Illaunbaun Wind Farm - Environmental Impact Assessment Report

Appendix A06-01: Scoping Consultation Responses

Figure 5-15: Anticipated Grid Connection Route

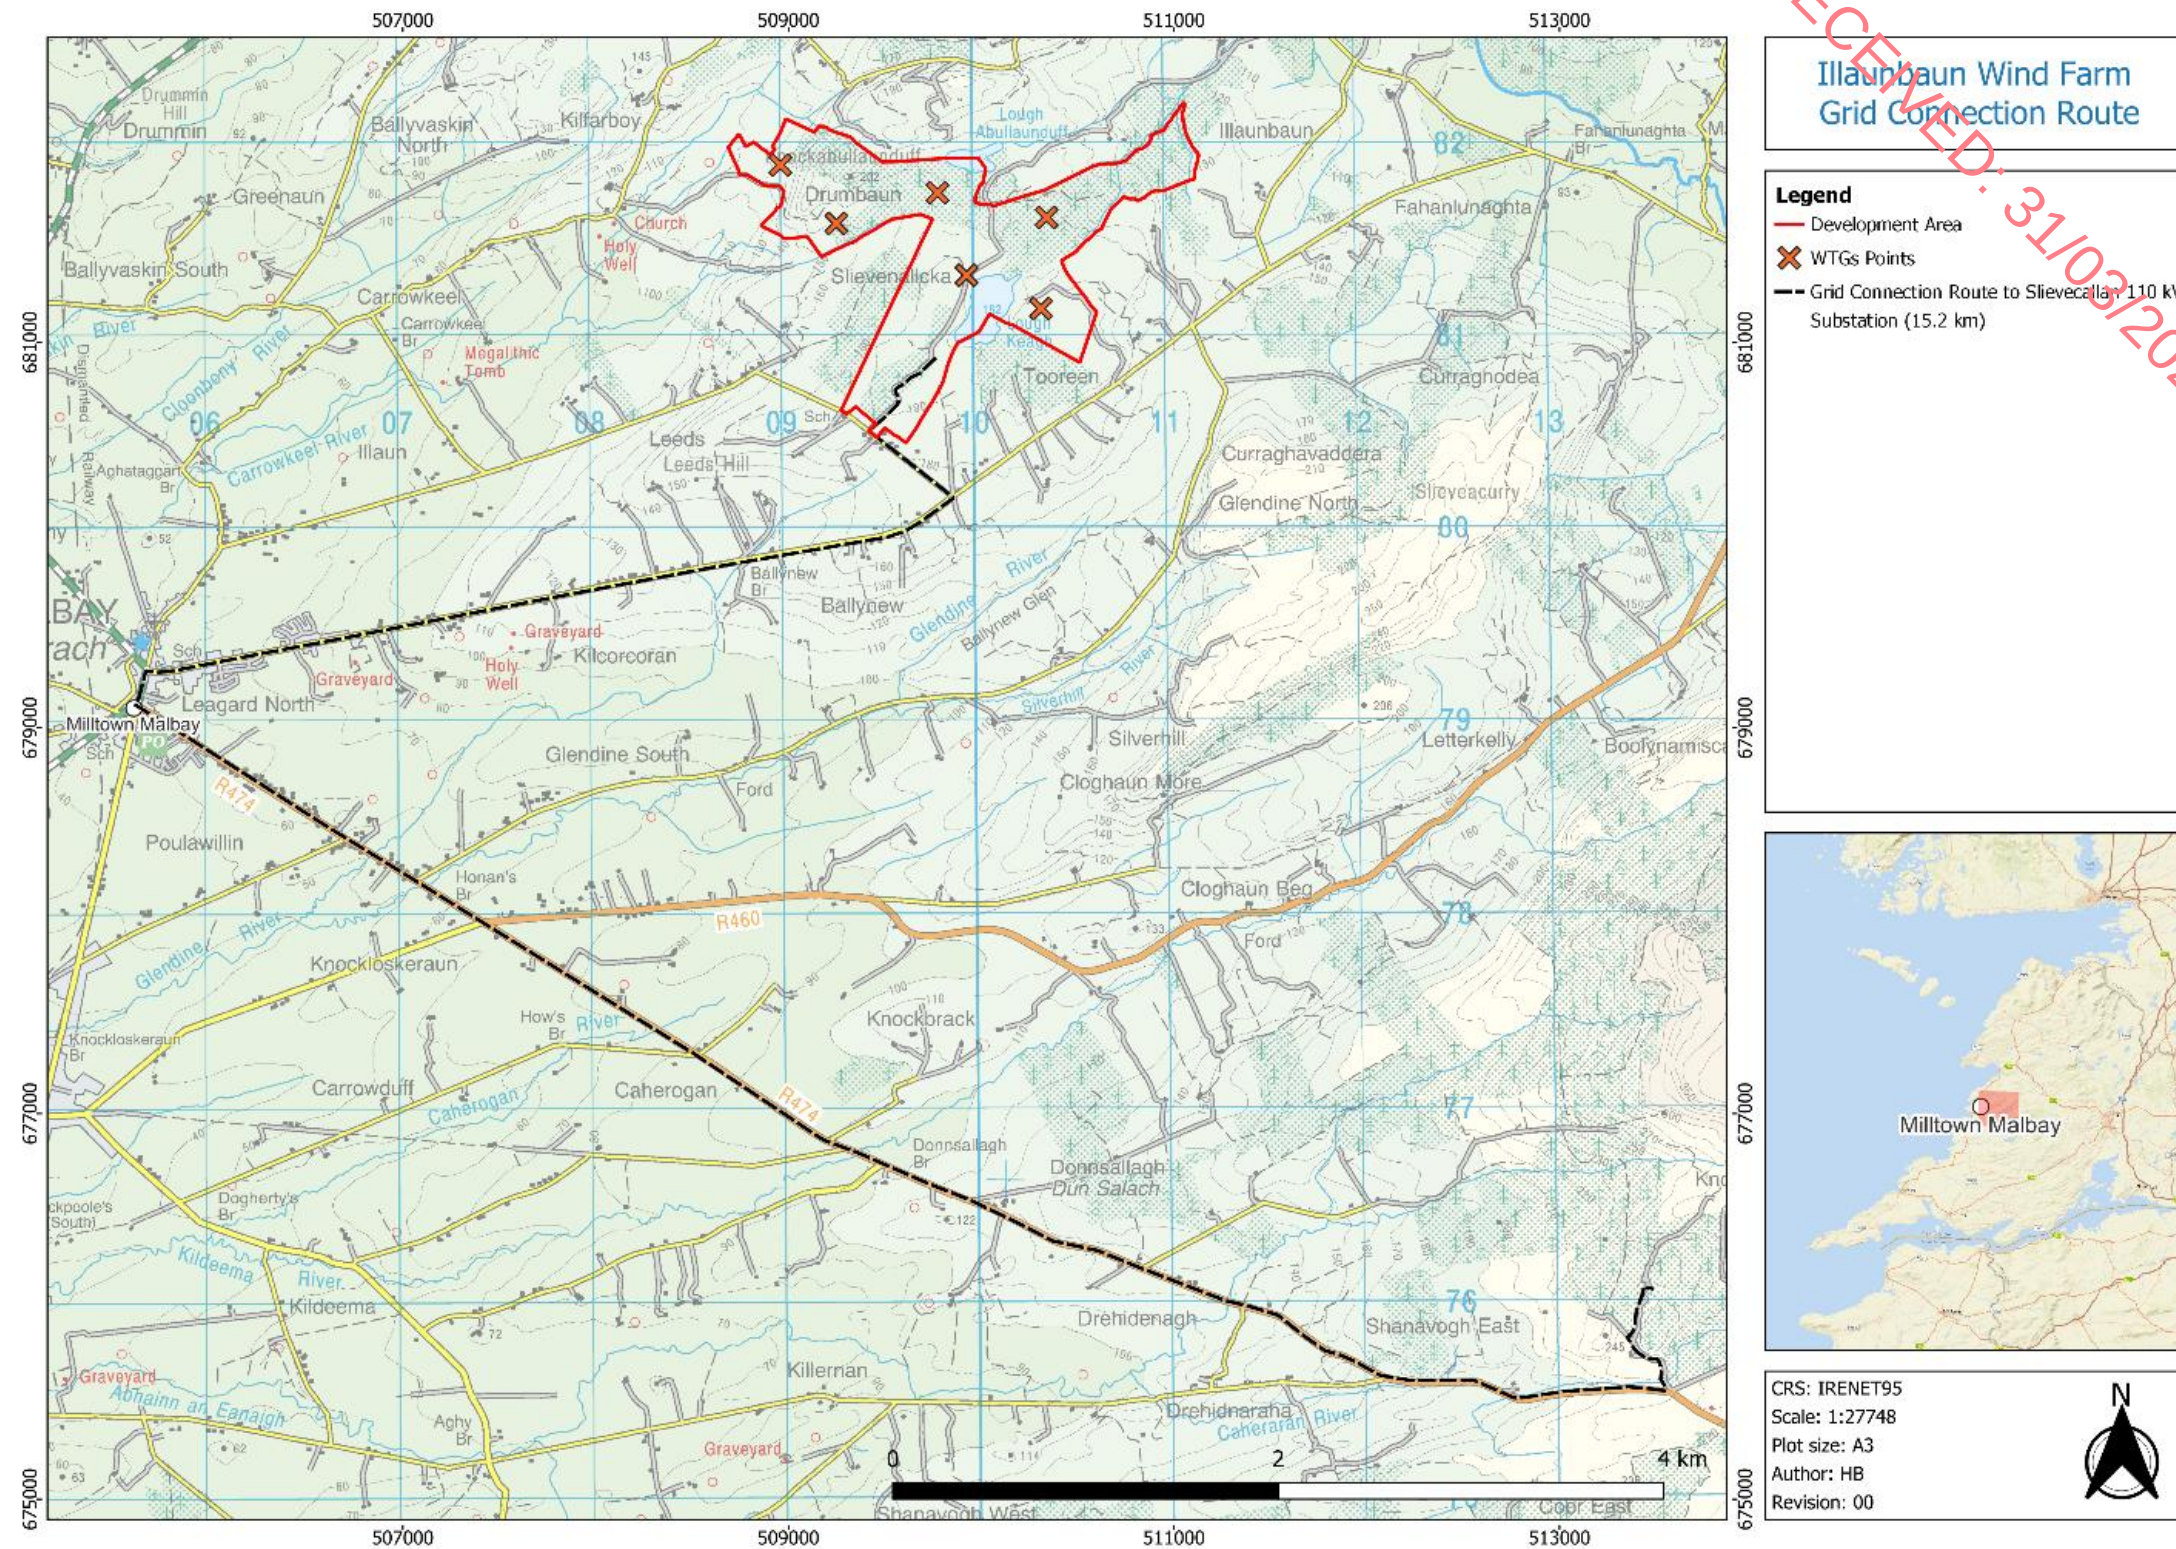
trenches and can impact on ability and cost of general maintenance, upgrades and safety works to existing national roads. Figure 2-3 of the EIAR Scoping Report outlines a Grid Connection Route and it is noted that proposals currently include utilising a section of urban N67, national road, in Milltown Malbay. Having regard to the foregoing, in TII's opinion, the grid connection routing, where it is proposed to utilise the road network, must demonstrate that the route proposed represents the 'optimal solution' . In addition, there is a finite road space available to accommodate all utilities in the road network and TII recommends that a co-ordinated approach to grid connection routing in this area is achieved to avoid risk to the effective delivery of renewable energy projects in the area. Other consents or licences may be required from the road authority for any trenching or cabling proposals crossing the national road. TII requests referral of all proposals agreed and licensed between the road authority and the applicant, which affect the national road network . Cable routing should avoid all impacts to existing TII infrastructure such as traffic counters, weather stations, etc. and works required to such infrastructure shall only be undertaken in consultation with and subject to the agreement of TII. Any costs attributable shall be borne by the applicant/developer. The developer should also be aware that separate approvals may be required for works traversing the national road network. All crossings in the vicinity of the national road should be by HDD and avoid all national road structures, including bridges, culverts, etc
